Recommendation Report for Planning Permission for Works or Extension to a Dwelling

REF NO: EP/23/22/HH

LOCATION: 5 Chiltern Close
East Preston
BN16 1RE

PROPOSAL: Conversion of roofspace to habitable, including hip to gable enlargement and a rear dormer and front rooflight, single storey rear extension, and timber framed lean to porch to front.

GROUND FLOOR &
FIRST FLOOR PLAN
AS PROPOSED

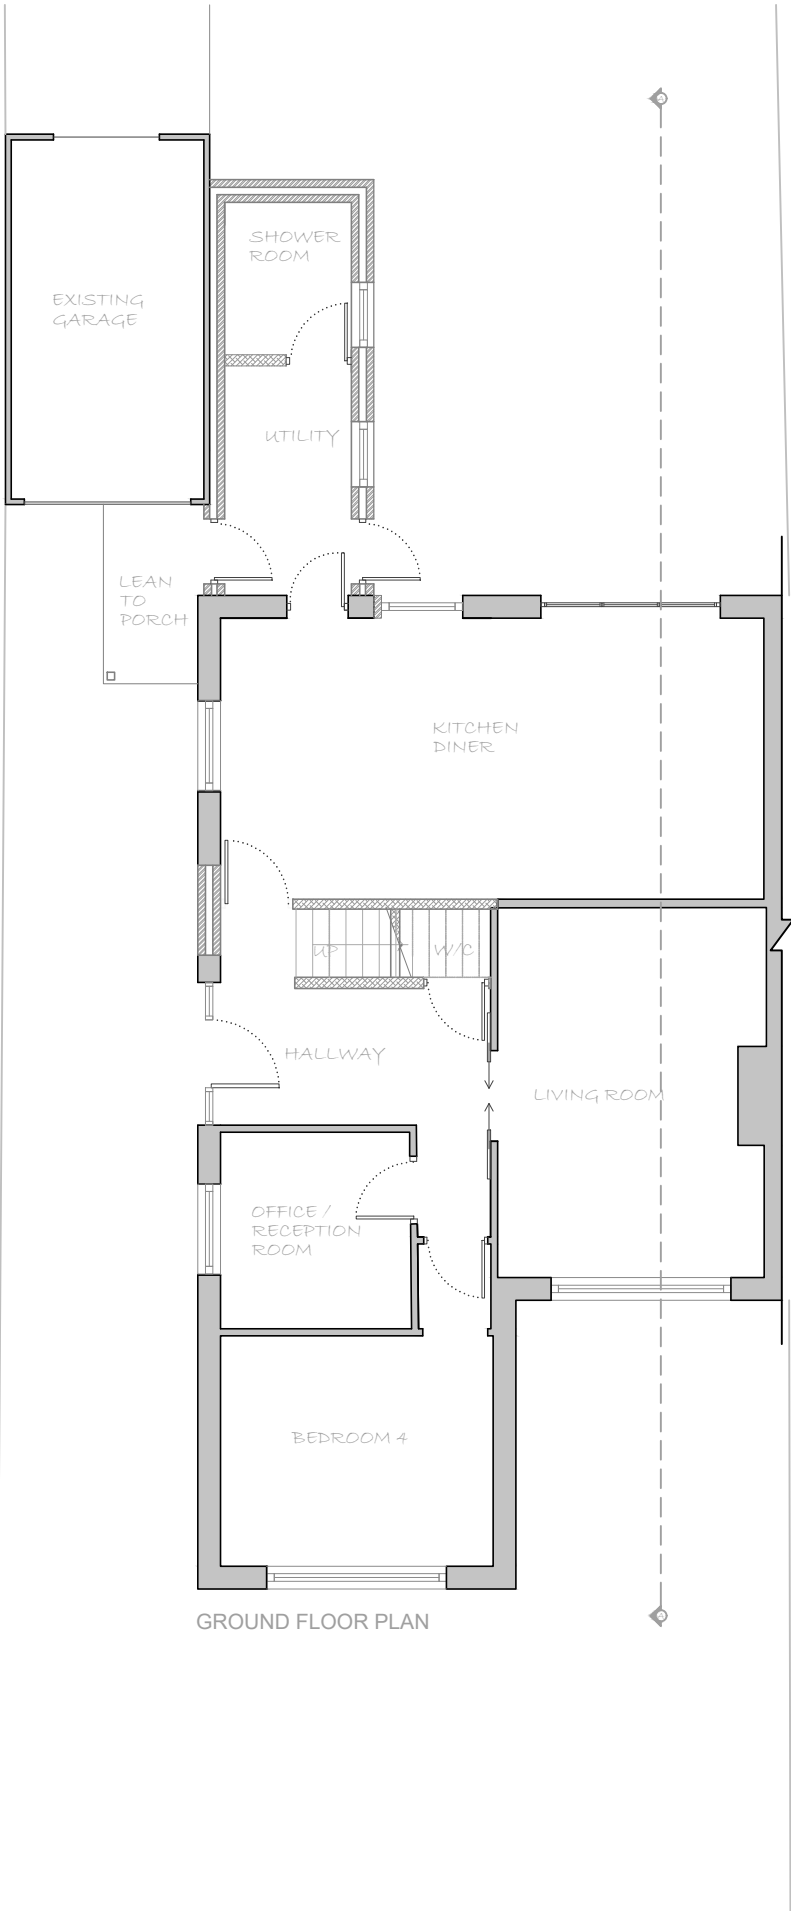
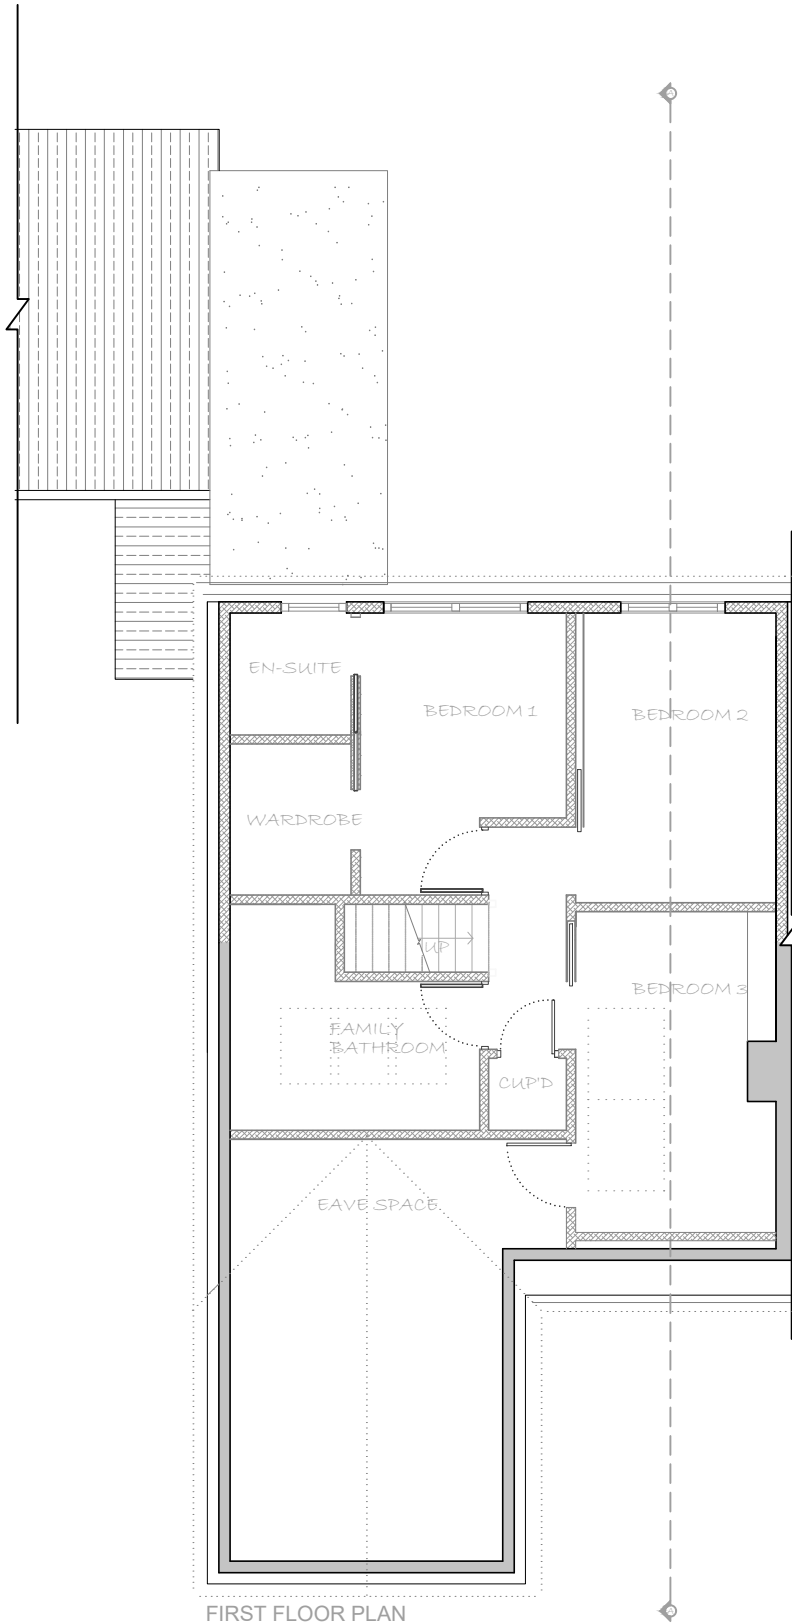
DESCRIPTION OF APPLICATION This application seeks a hip to gable roof extension, rear box dormer, single storey rear extension measuring approx. 2.2m by 5.8m and an open sided porch.

The bulk of the development will be above the existing footprint of the dwelling, under Design Guidance this is seen as an effective use of the plot. The rear extension protrudes 5.8m into the rear garden but it is situated away from the boundaries by over 5m to the east and is obscured by a garage immediately to the west. A rear garden length, above design guidance recommended levels is retained for the majority of the garden, lowering to 7.8 to the north of the single storey extension, this is acceptable given the good garden length to the opposing property.

In terms of overlooking, queries have been raised relating to the roof lights to the southern elevation. Although larger than most, these will not harm the amenity of adjoining neighbours as the face the highway. The rear facing windows will overlook the private amenity space at the rear, as such there will be no negative impact from overlooking.

ELEVATION AND
SECTIONAL ELEVATION
AS PROPOSED

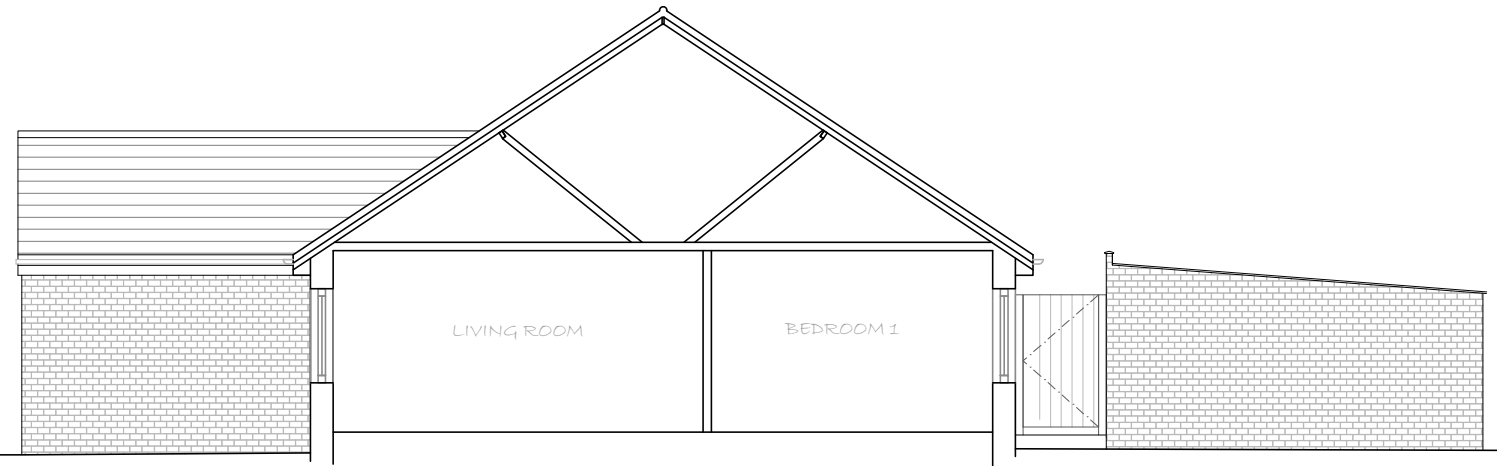
- Hip to gable extension will have a negative impact to street scene.
- Unbalance pair of semi-detached bungalows.
- Rear dormer overly dominant.
- Question front rooflight.

- No objection to rear extension.
- Hip to gable extension will have a negative impact to street scene.
- Unbalance pair of semi-detached bungalows.
- Rear dormer overly dominant.

The hip to gable roof extension will not significantly alter the appearance of the bungalow. Given the existing character and appearance of the area it will not appear out of keeping. Furthermore although the shape of the roof will alter, the ridge height will not be increased thereby retaining its bungalow single storey appearance.

The proposed dormer roof is small enough so that it could be built without the need for planning permission. The dormer is designed to be set in from both ends and to sit below the roof ridge which will make it look balanced and provide it with an acceptable appearance.

The spatial character of the area will not be compromised with the addition of the dormer window or hip to gable extension, as further to the works a semi-detached chalet dwelling, which is comparable in scale to others in the area will be retained.
